KIRKLEES METROPOLITAN COUNCIL INVESTMENT & REGENERATION SERVICE

DELEGATED DECISION TO DETERMINE PLANNING APPLICATIONS

Reference No:	2025/62/92986/E
Site Address:	23, Westgate, Dewsbury, WF13 1JQ
Description:	Alterations to former office/retail to form 3 first floor flats (within a Conservation Area)
Recommending Officer:	Elenya Jackson

DECISION – CONDITIONAL FULL PERMISSION

PROPOSED FIRST FLOOR PLAN
Scale 1:50@A1

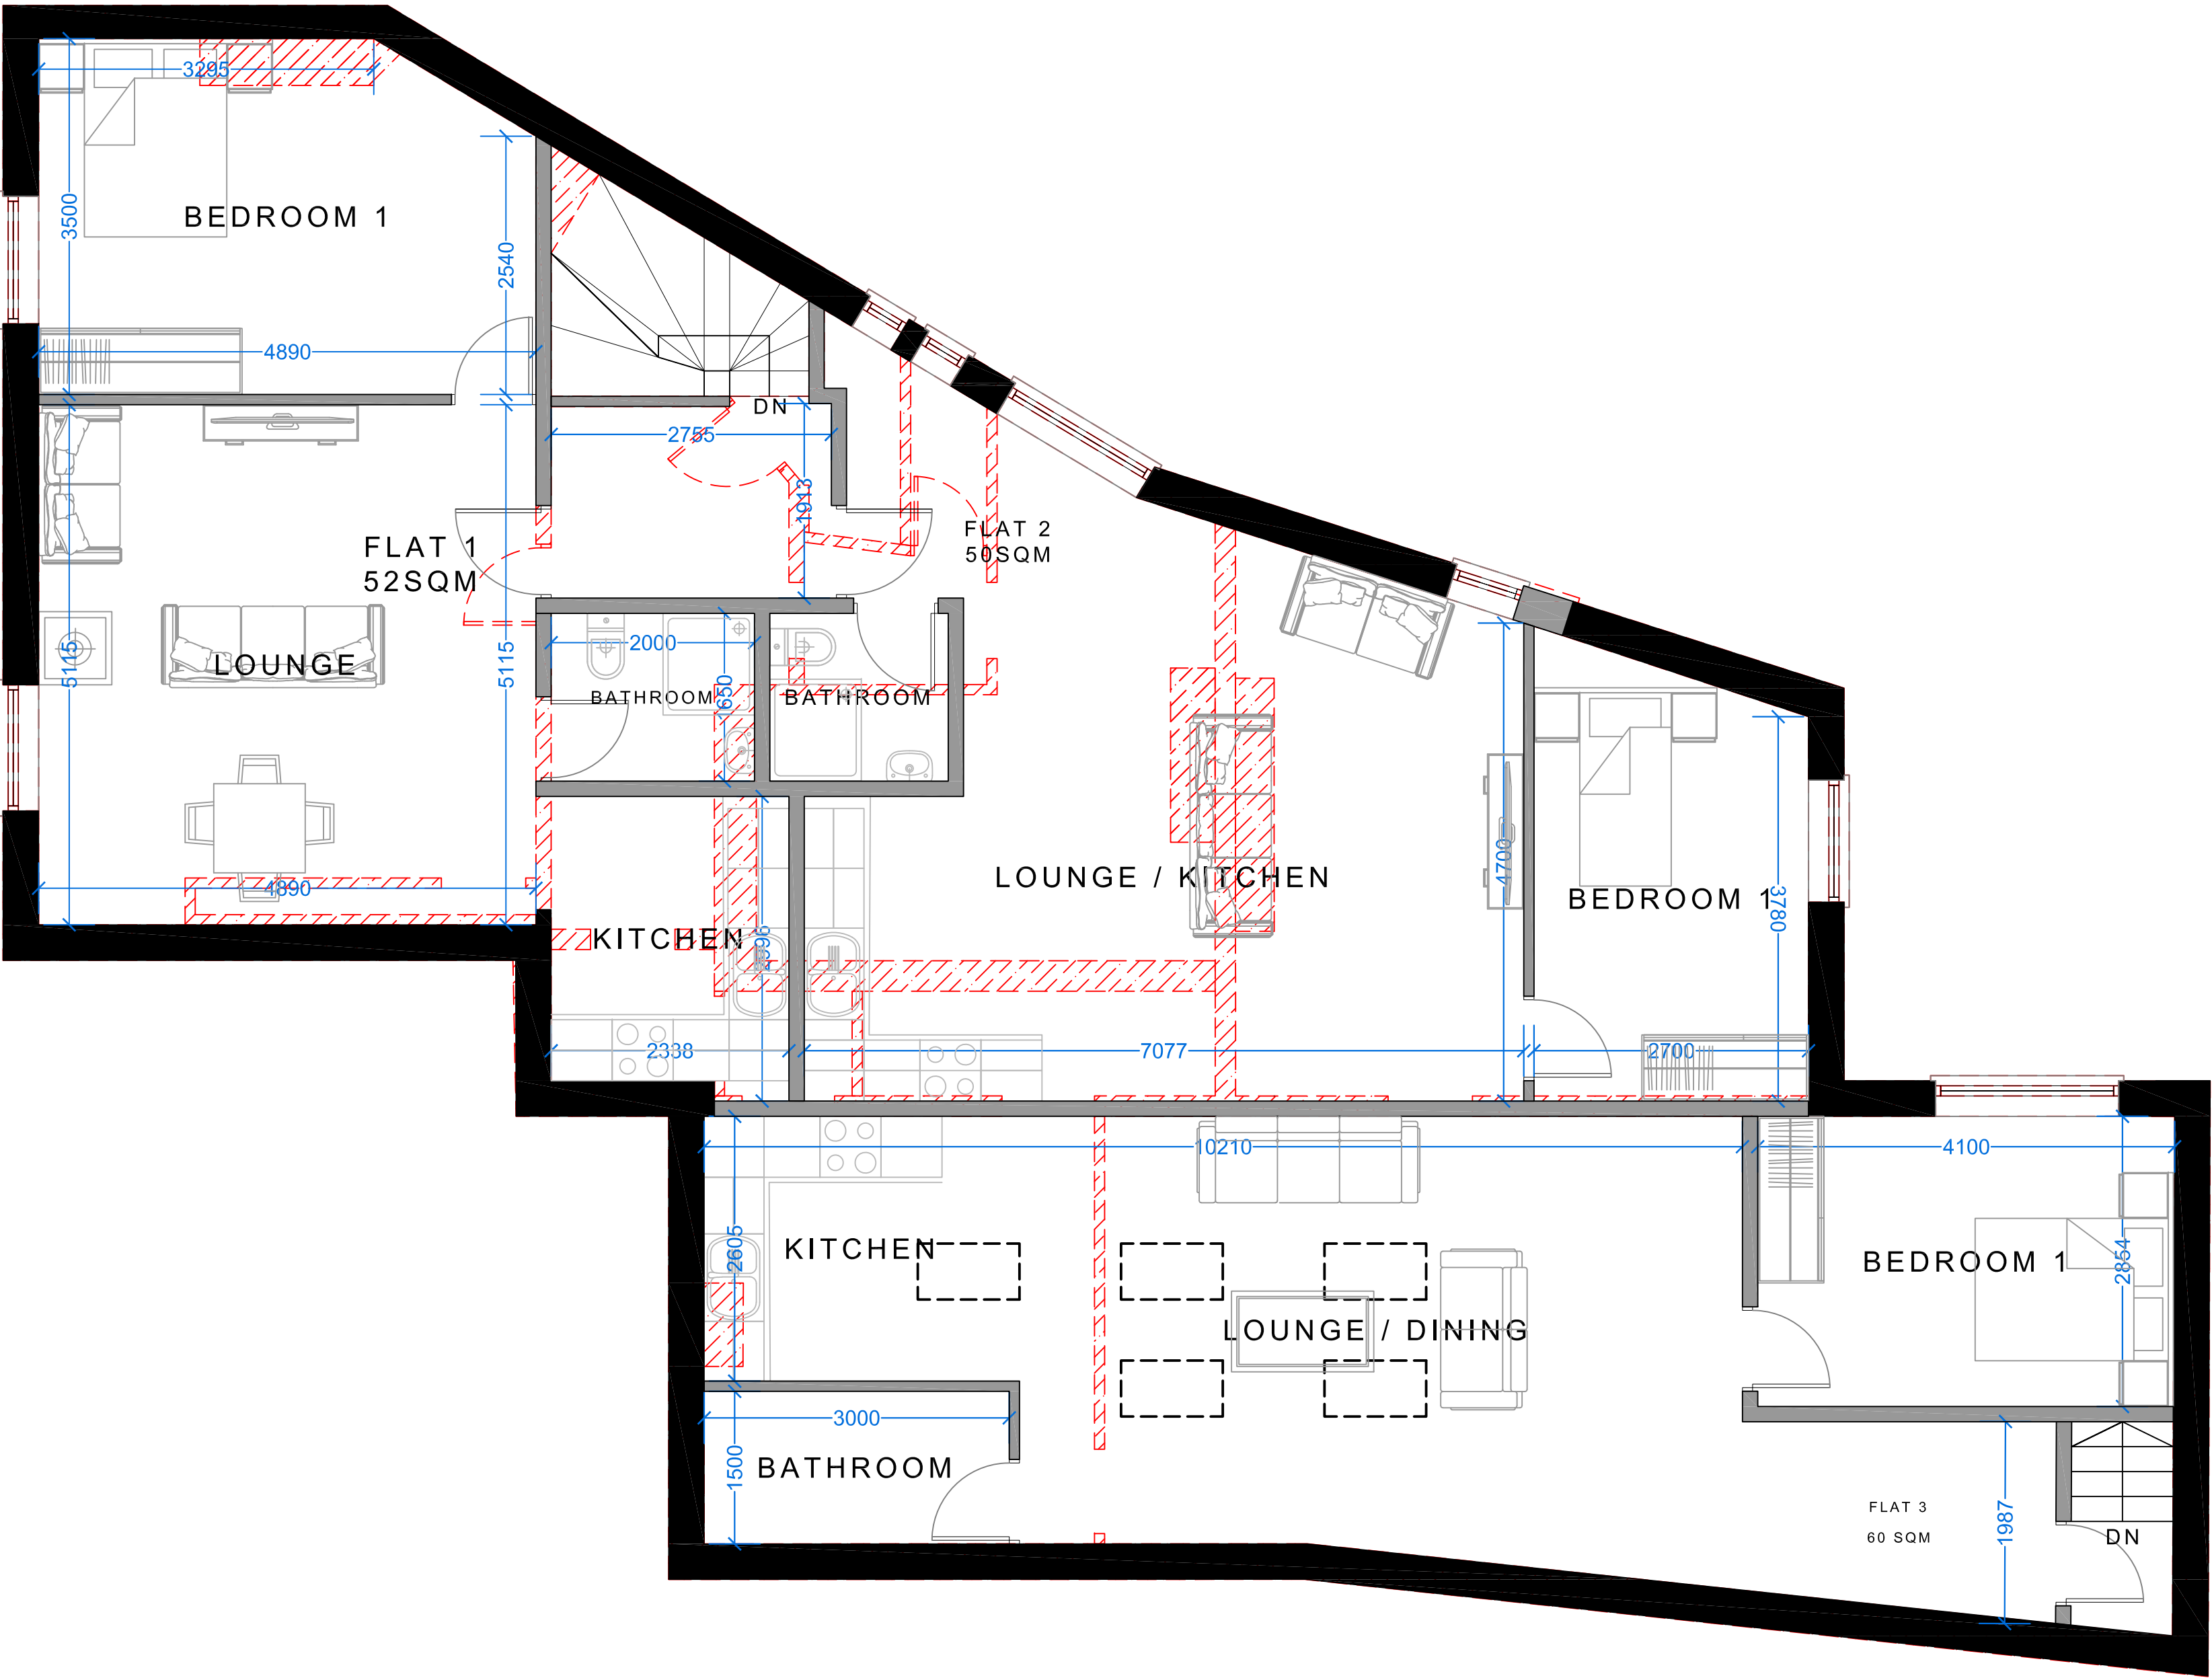
The proposal shows all flats to have a minimum floor space of 50m² per flat. It is considered that an acceptable standard of living would be demonstrated. The locality benefits from close access to areas available as public open space and as such whilst limited amenity space is provided, there are public areas available as amenity space(s) able to be utilised by occupants.

Overlooking: The proposal would have side facing windows for habitable rooms, the bedroom of flat 3 would face onto 7 Westgate which has two side facing windows. It is considered that, these windows have an existing established relationship between the properties.

PROPOSED ROOF PLAN
Scale 1:100@A1

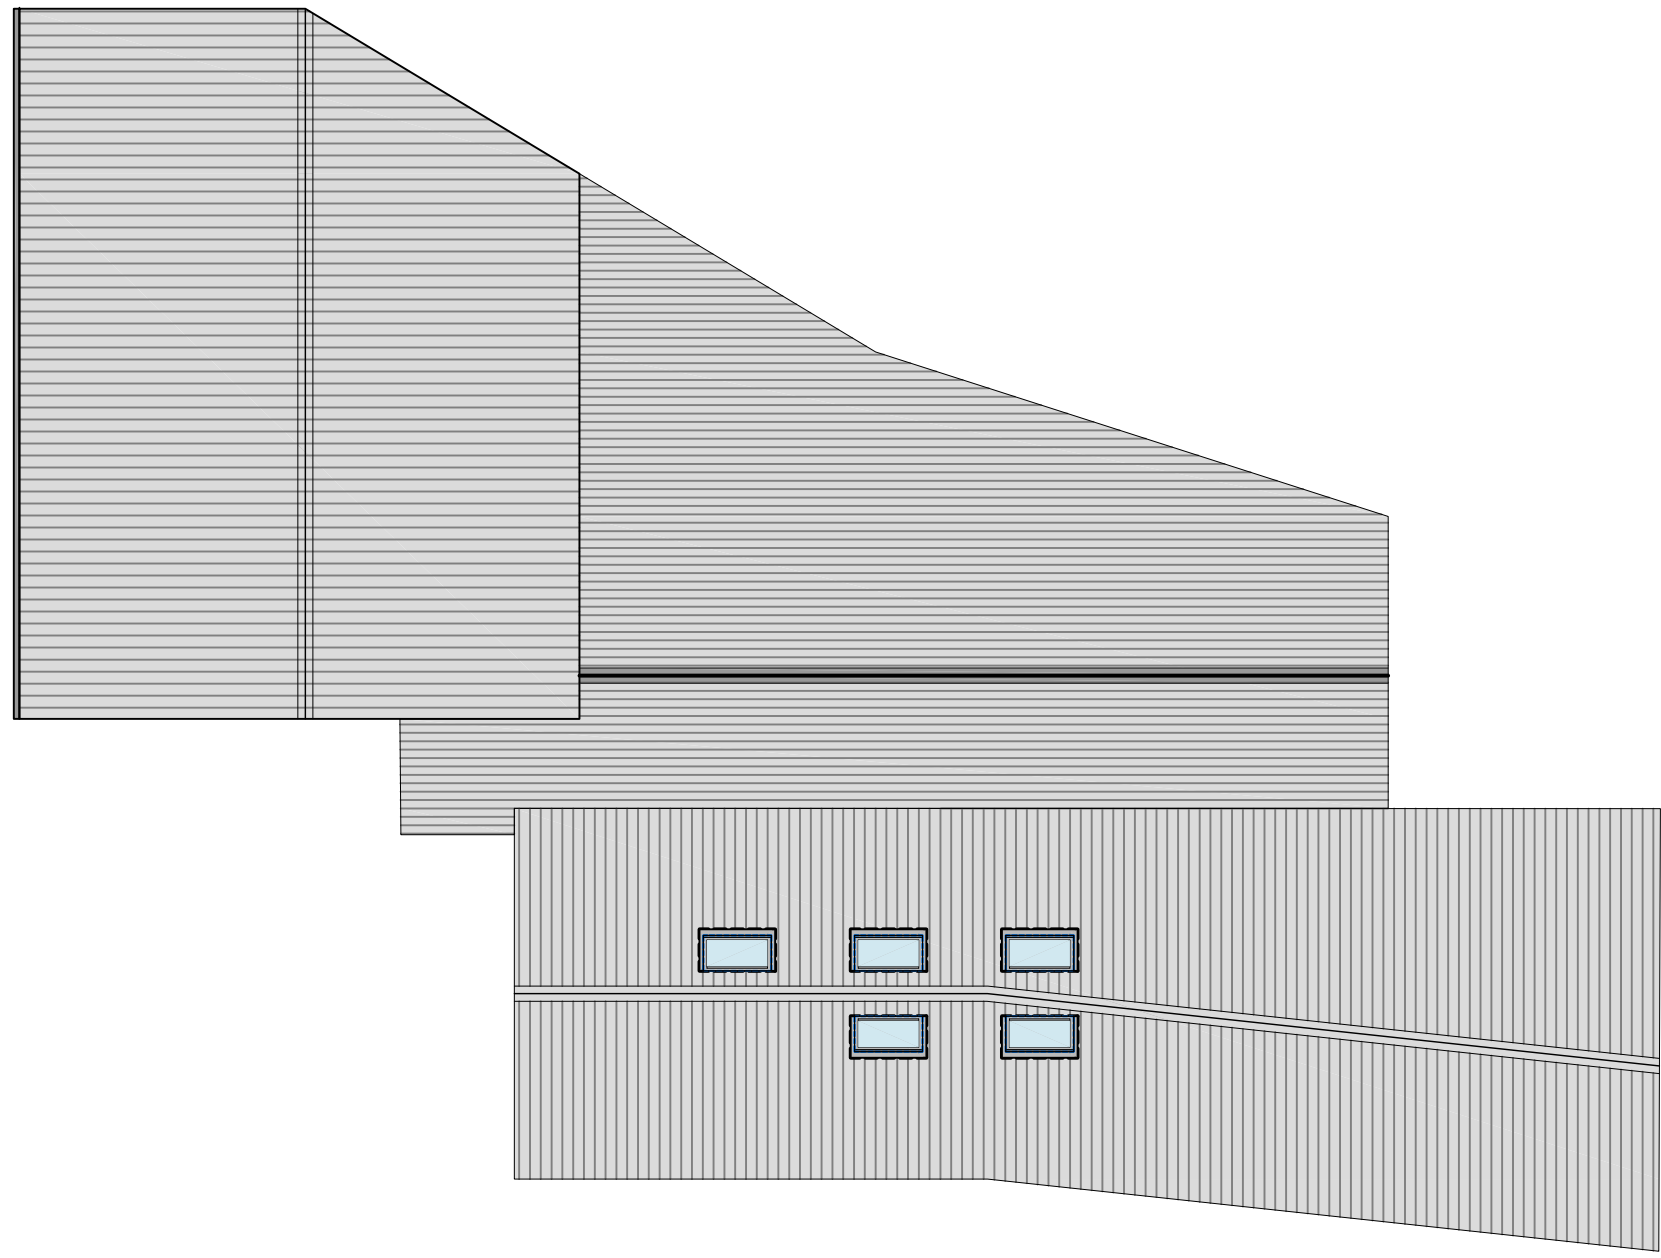
The plans provided demonstrate that there are minimal external alterations to the existing building with the exception of roof lights.

As previously outlined, the proposal would have minimal alterations to the external appearance of the building with the exception of some roof lights. It is considered that it could be conditioned for these to conservation roof lights.
